Colorado Springs, CO

Final Report - Corrections Required **Application No. LUPL-25-0008**

Document Filename : 241010_BLR Village C Land Use Plan.pdf

BANNING LEWIS RANCH - VILLAGE C

P:\2024\24-1010_BLR_Village_C\Drawings\241010_BLR_Village_C_Land_Use_Plan.dwg 6/13/2025 10:27 AM

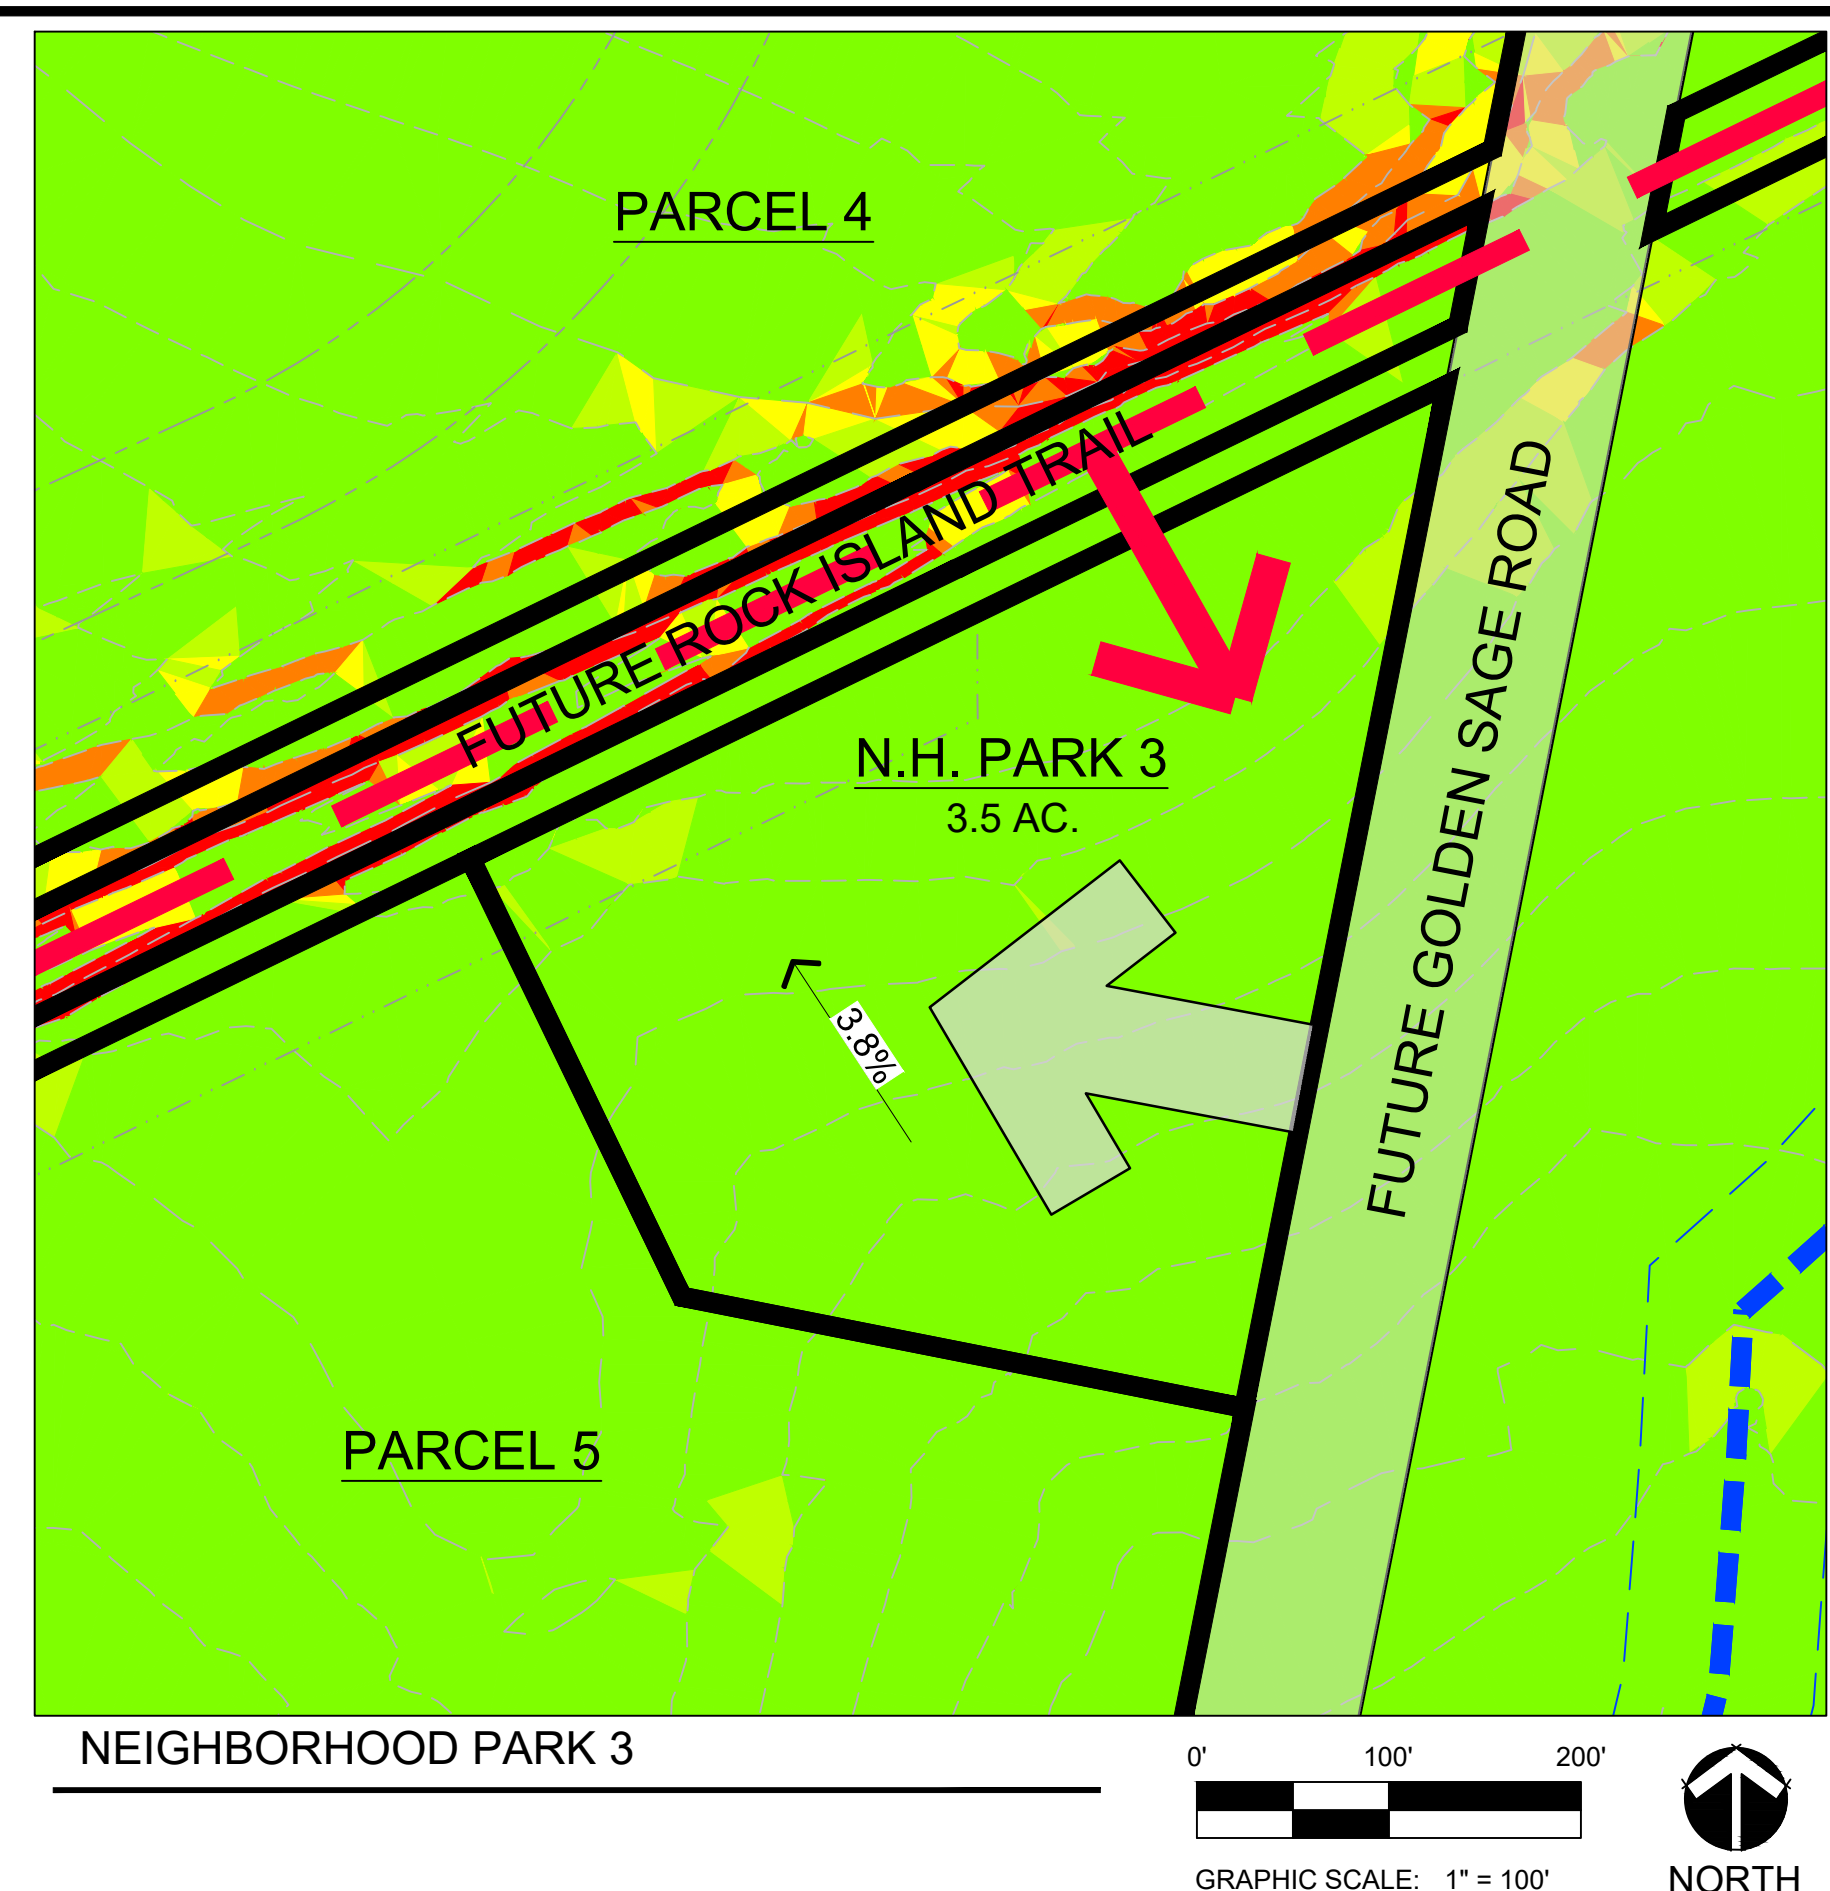
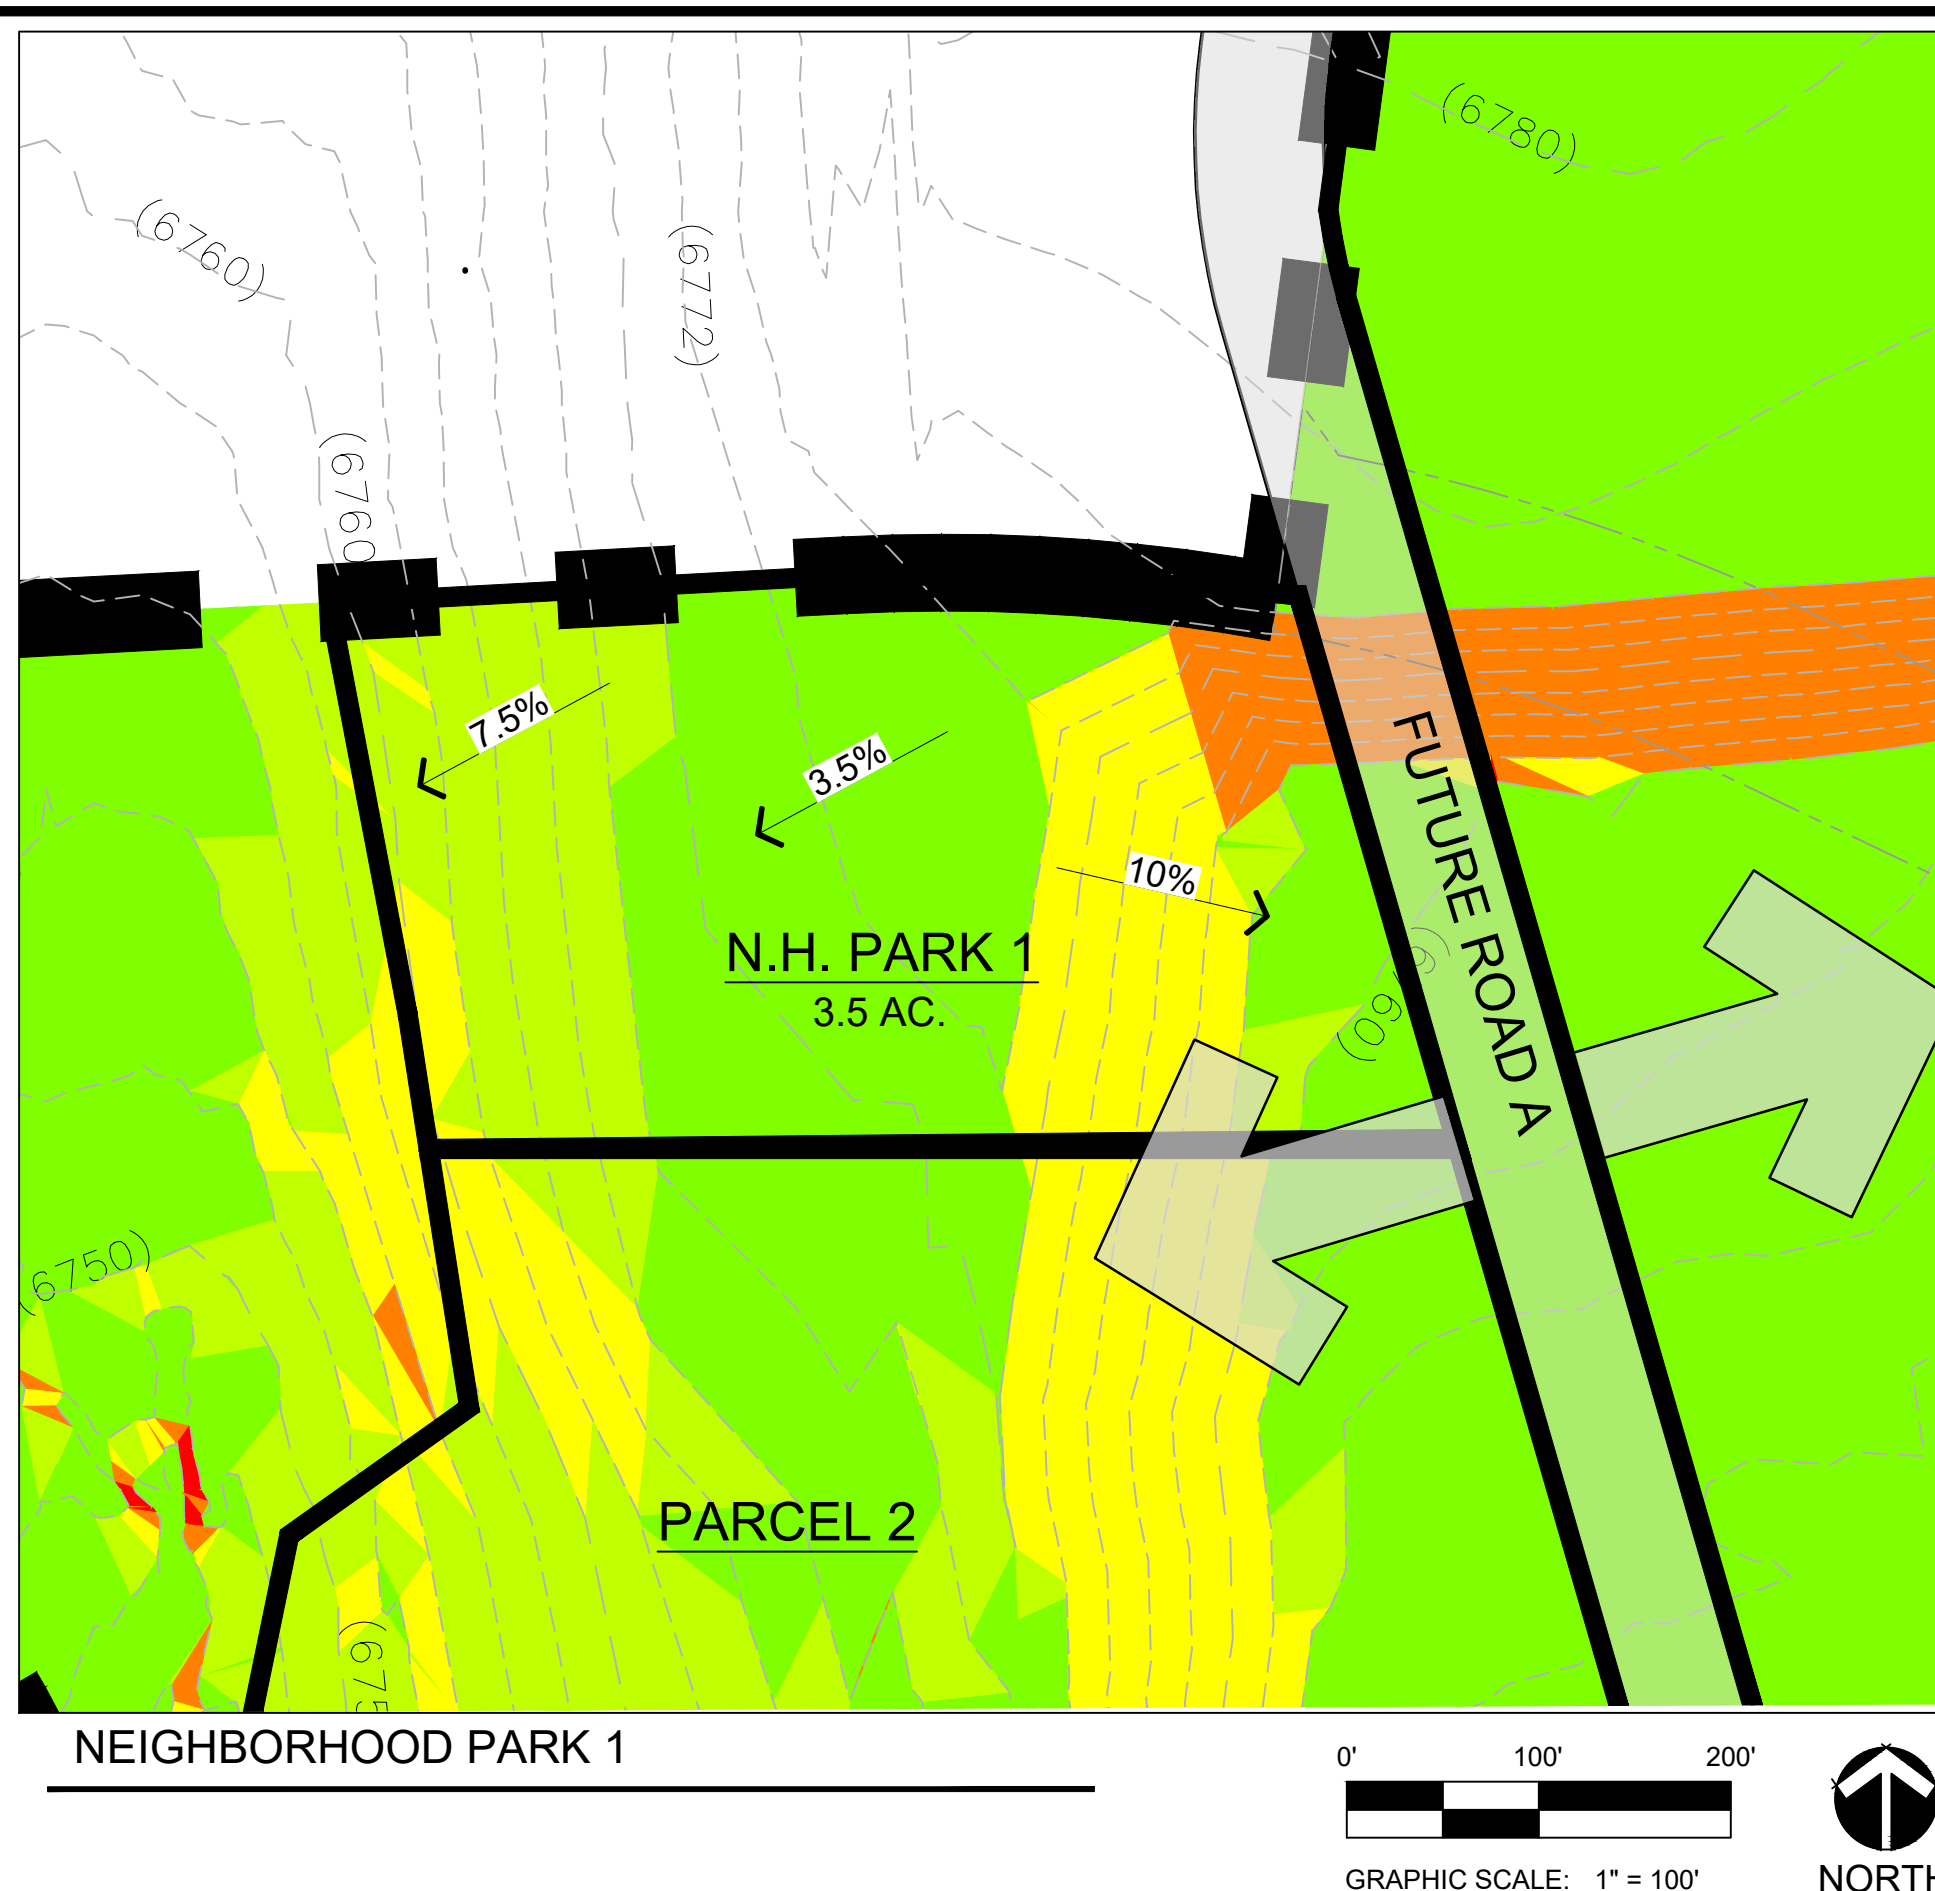
Comment ID	Page Reference	Reviewer : Department	Review Comments
16	2	Caroline Miller : Planning	Informational - More Parks comments or edits are likely to be requested.
19	2	Caroline Miller : Planning	Please revise all proposed zones - PDZ for Parks and Schools is no longer proposed.
21	2	Caroline Miller : Planning	As shown, there is a need for pedestrian bridges to allow connection to the Community Park site. Will the developer provide those?
22	2	Caroline Miller : Planning	As communicated with the developer team, May 2025, BLR Village A is to be viewed as a separate development, removing the Community obligation of Village A from Village C. Please remove all references to Village A acreage. PLDO reviewer acknowledges that with this direction, the Community Park size is required to meet B2 & C obligations is 28.7 acres, though additional acreage would be supported in creating a larger, more versatile site, and better meeting Community Park Site characteristics.

23	2	Caroline Miller : Planning	Please add Village B2 Community Park acreage to table, as it is carried over from Village B2.
24	2	Caroline Miller : Planning	Please recalculate math for Community Park obligations for Village C and B2. Reviewer calculates 11.568 for Village C and 17.128 for Village B2 with units shown.
26	2	Caroline Miller : Planning	Please confirm, in prior LUP Review (PDZL-24-0005) 1,841 units were used as an average for PLDO calculations. Now, this number has been revised to 1,446 to account for 6 du/ac (Note 1) where the mean unit count is now 2,285. Please confirm with staff which count is more accurate. Typically staff would go with average.
28	2	Caroline Miller : Planning	Notes 2 and 4 need to be updated with accurate acreages and reflect that Village A is no longer included.
29	2	Caroline Miller : Planning	Staff sees 4 3.5 acre parks totaling 14 acres of Neighborhood Parks. Are there any notes that need to be added regarding the 4th park site considering future multifamily development? Is the intent that the future multifamily development will be meeting Neighborhood Park PLDO through this dedication, with Community Park fees in lieu due? Staff is supportive of the eastern 4th park site, as it is geographically separate from the rest of Village C and a benefit to the residents there.

32	2	Allison Stocker : Planning	Label creek name and type
42	2	Tamara Baxter : Planning	Refer to EPC, EPC Engineering and District 49 comments which were uploaded to file.
43	2	Tamara Baxter : Planning	Please see separate email dated 6.25.25 from City Budget Office sent separately.
44	2	Tamara Baxter : Planning	Single Family detached are conditional use in the MX-M zone district.
45	2	Tamara Baxter : Planning	Please clarify what is intended as "Mixed-Use", does this anticipate more than commercial and residential per UDC?
46	2	Tamara Baxter : Planning	Add the AP-O and SS-O overlays to the proposed zone district labels.
47	2	Tamara Baxter : Planning	Add the "SS-O" overlay to the proposed zone district labels
49	2	Tamara Baxter : Planning	Is this both detached and attached?
50	2	Tamara Baxter : Planning	This range does not include the proposed residential density in parcel 6, 7, 8 and 9.
52	2	Tamara Baxter : Planning	The UDC does not define Mixed-Use. Can you please clarify. Does this encompass the uses that are allowed or conditional in the MX-M zone district? Are there uses that you want to restrict?

53	2	Tamara Baxter : Planning	Please use this on the coversheet as well.
54	2	Tamara Baxter : Planning	What does this residential encompass?
30	3	Caroline Miller : Planning	This graphic doesn't match the LUP Bubbles shown on page 2, park is not next to Public Safety.
